**Planning Department  
Transportation Development Services**

August 17, 2015

**Re: Calvary Chapel Remodel  
6510 Fortuna Rd., NW  
Traffic Circulation Layout**  
Engineer's/Architect's Stamp dated 8-7-15 (J10-D003)

Based upon the information provided in your submittal received 8-7-15, the above referenced plan cannot be approved for Building Permit until the following comments are addressed:

Conceptual Site Plan

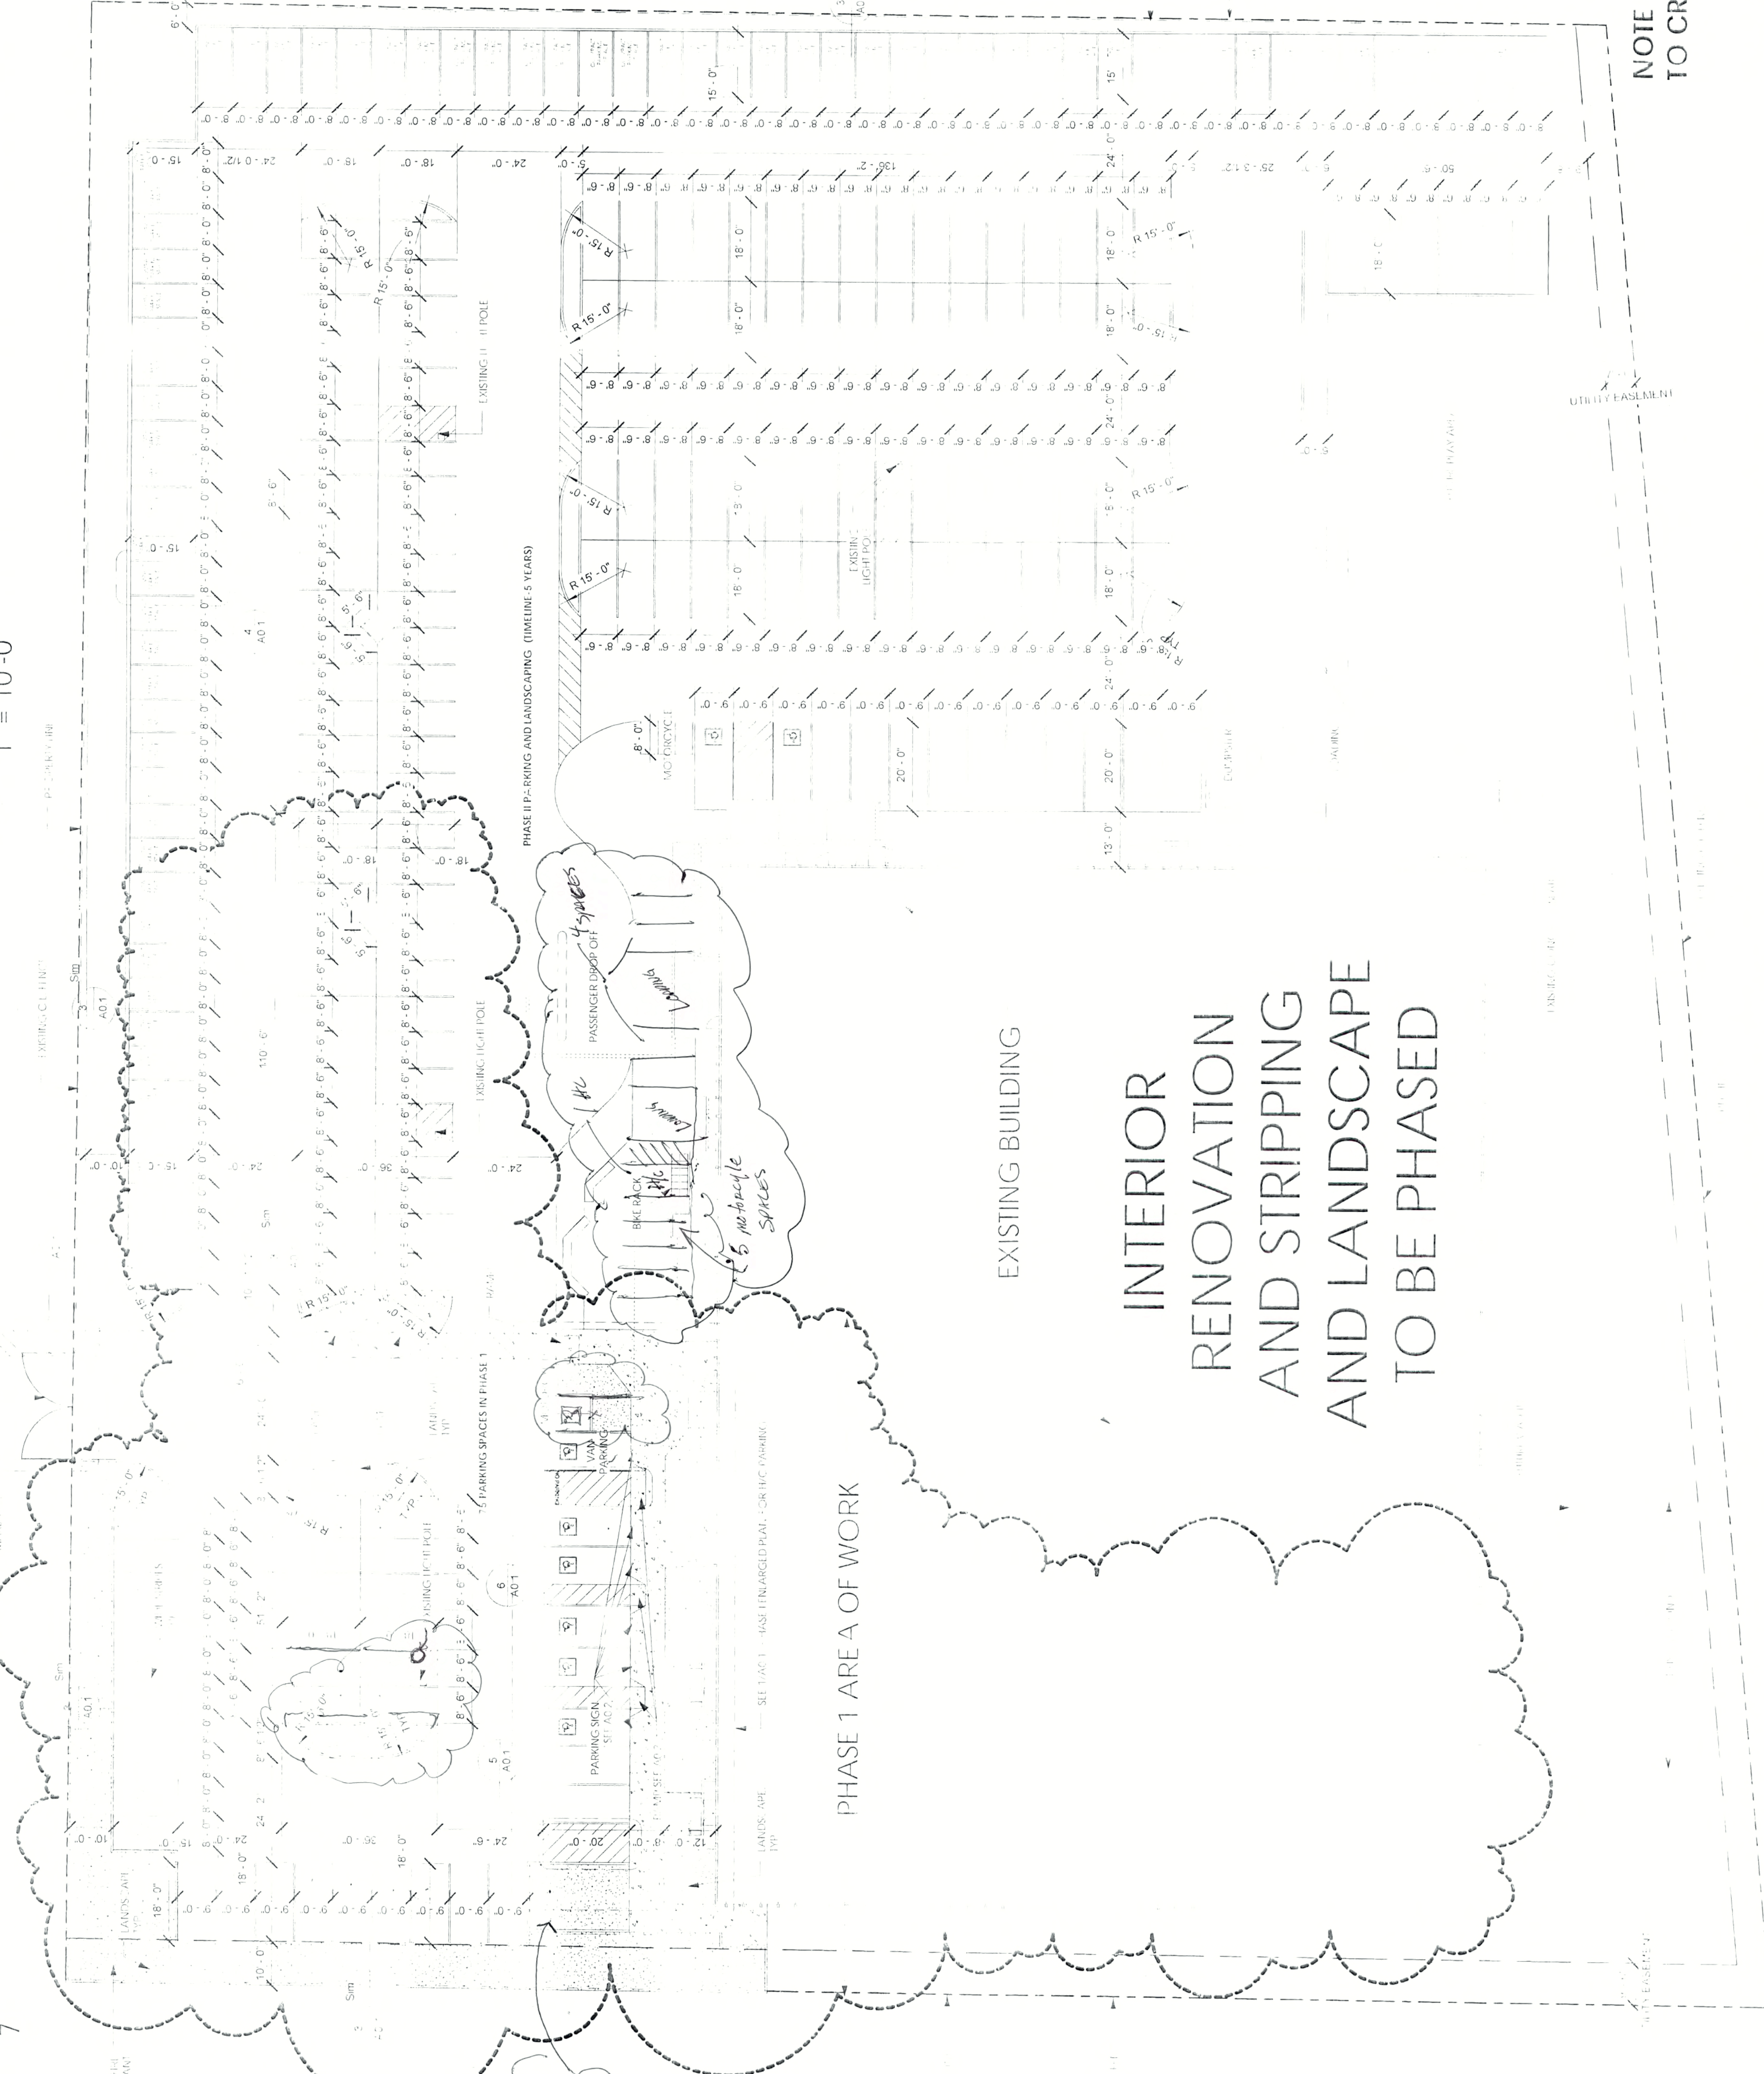
1. Identify the right of way width, medians, curb cuts, and street widths on Fortuna Rd.
2. Please list the width and length for all parking spaces.
3. Label the compact parking spaces by placing the words "**COMPACT**" on the pavement of each space.

4. The ADA accessible parking sign must have the required language per 66-7-352.4C NMSA 1978 "**Violators Are Subject to a Fine and/or Towing.**" Please provide a detail of signage and it's proposed location.

5. The ADA access aisle shall have the words "**NO PARKING**" in capital letters, each of which shall be at least one foot high and at least two inches wide, placed at the rear of the parking space so as to be close to where an adjacent vehicle's rear tire would be placed. (66-1-4.1.B NMSA 1978) Please show this detail on the drawing.

6. Show all drive aisle widths and radii for all phases of the project.
7. List radii for all curves shown; for passenger vehicles, the minimum end island radius is 15 feet. Landscape island radius for delivery trucks, fire trucks, etc. is 25 feet or larger.

8. Per the DPM, a 6 ft. wide ADA accessible pedestrian pathway is required from the public sidewalk to the building entrances. Please clearly show this pathway and provide details. Per review of drawing, there is only a 5 ft. pedestrian walk way provided from Fortuna Rd. to the building entrance.

9. Per the DPM, a 6 ft. wide ADA accessible pedestrian pathway is required from the HC parking stall access aisles to the building entrances. Please detail the slope from the ADA parking spaces to the pedestrian walkway.
10. Provide a min 6" or max 8" high concrete barrier curb or other acceptable barrier between landscaping and parking areas and/or drive aisles.
11. Design delivery vehicle route needs to be shown.
12. Service vehicle and/or refuse vehicle maneuvering must be contained on-site; provide a copy of refuse approval.
13. Please clarify how the site meets clear sight triangle requirements.
14. Please provide a sight distance exhibit (see the *Development Process Manual, Chapter 23, Section 3, Part D.5 Intersection Sight Distance*). Please provide this detail for the entrance from Fortuna Rd.

15. Please add the following note to the clear sight triangle: "Landscaping and signage will not interfere with clear sight requirements. Therefore, signs, walls, trees, and shrubbery between 3 and 8 feet tall (as measured from the gutter pan) will not be acceptable in this area."
16. Please specify the City Standard Drawing Number when applicable.
17. Please include a copy of your shared access agreement with the adjacent property owner.
18. Work within the public right of way requires a work order with DRC approved plans.
